Please ask for: Nicola Moore
Email: nicola.moore@arun.gov.uk
Telephone: Ext 37944
Our Ref: AL/12/21/CLP
Your Ref:
Date: 12th February 2021

Lawful Development Certificate for a Proposed Use or Development

Development: replace existing garden room/outbuilding
Location: Thatched Cottage Arundel Road Norton PO18 0JX

PLAN 2

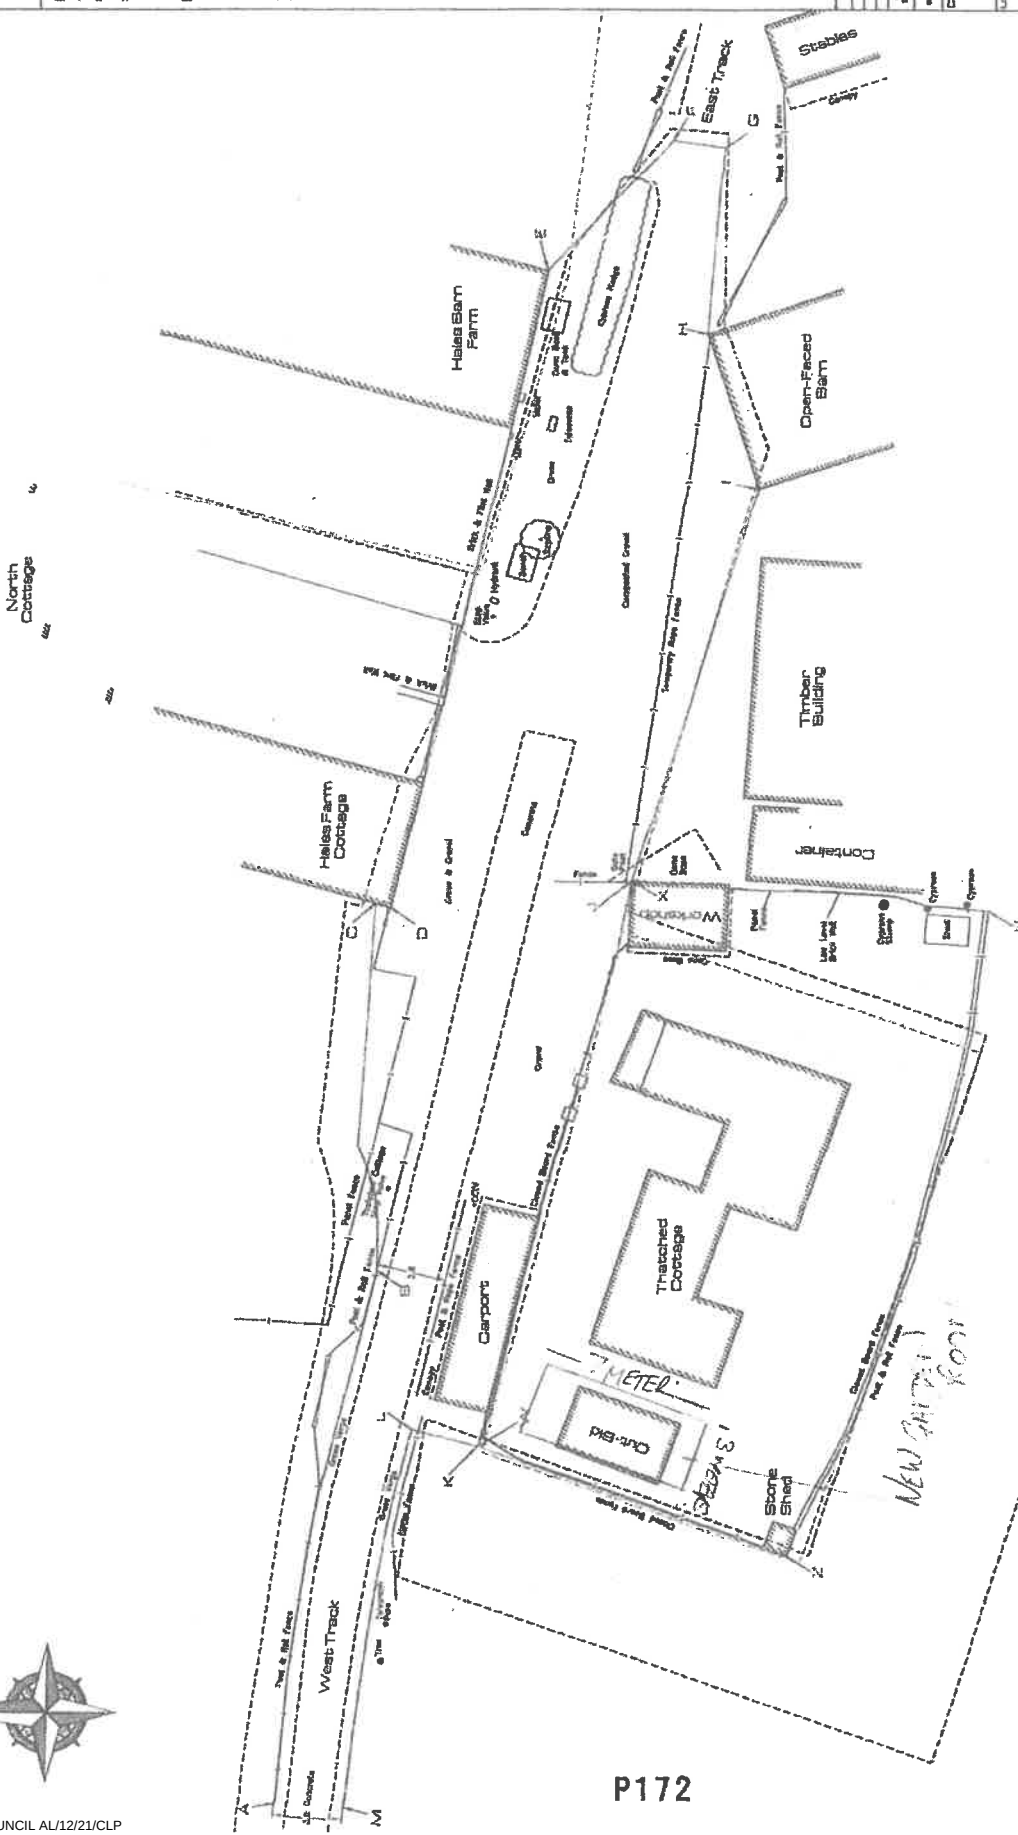
The submitted Block plan does not appear to be to scale. Please confirm the scale and re submit ensuring the PDF is to scale, or, remove the scale bar.

SOUTH SIDE

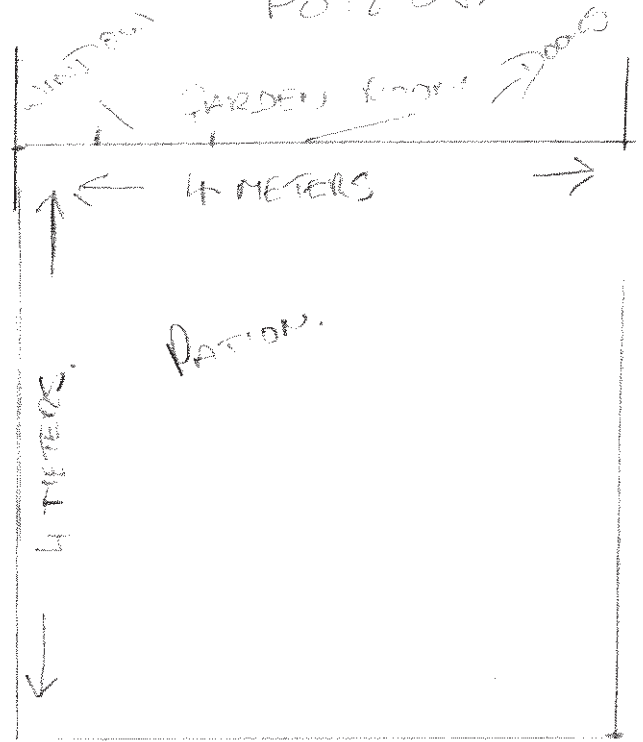
You have submitted 2 East Elevations but no South Elevations. Please check the labelling, amend accordingly and re submit.

Please clarify the measurements of the proposed outbuilding as on the Site Plan they are shown as 7m x 3m but on all other plans 7m x 4m.

EAST SIDE.

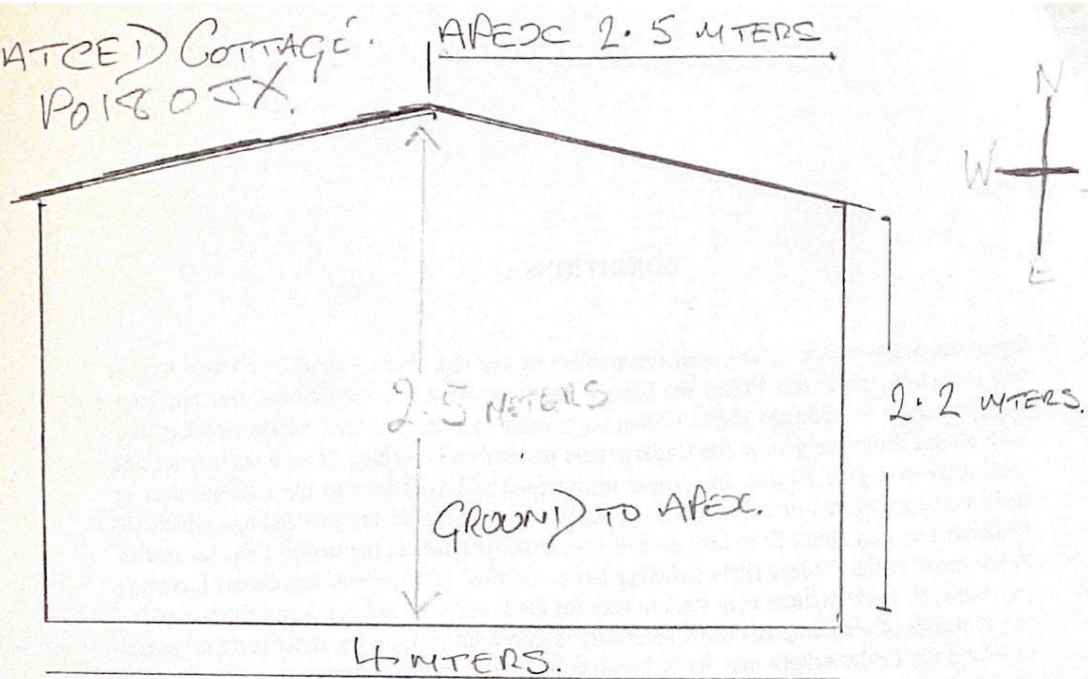
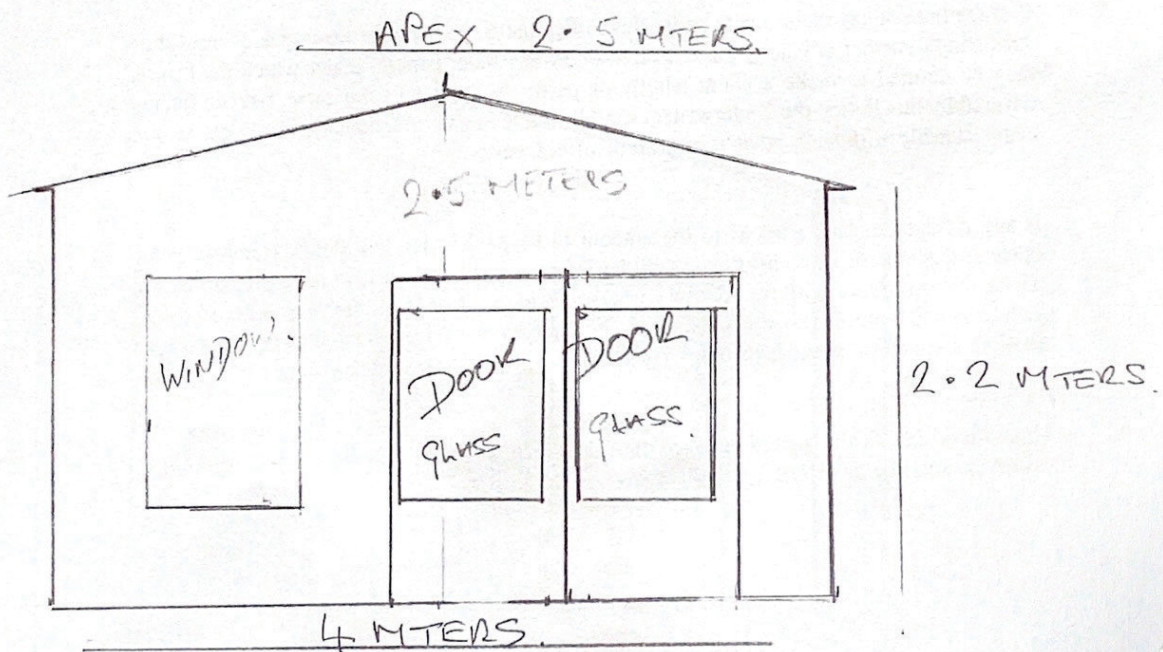
The submitted elevations should be clearly labelled Proposed. Please amend accordingly and re submit as PDF files.
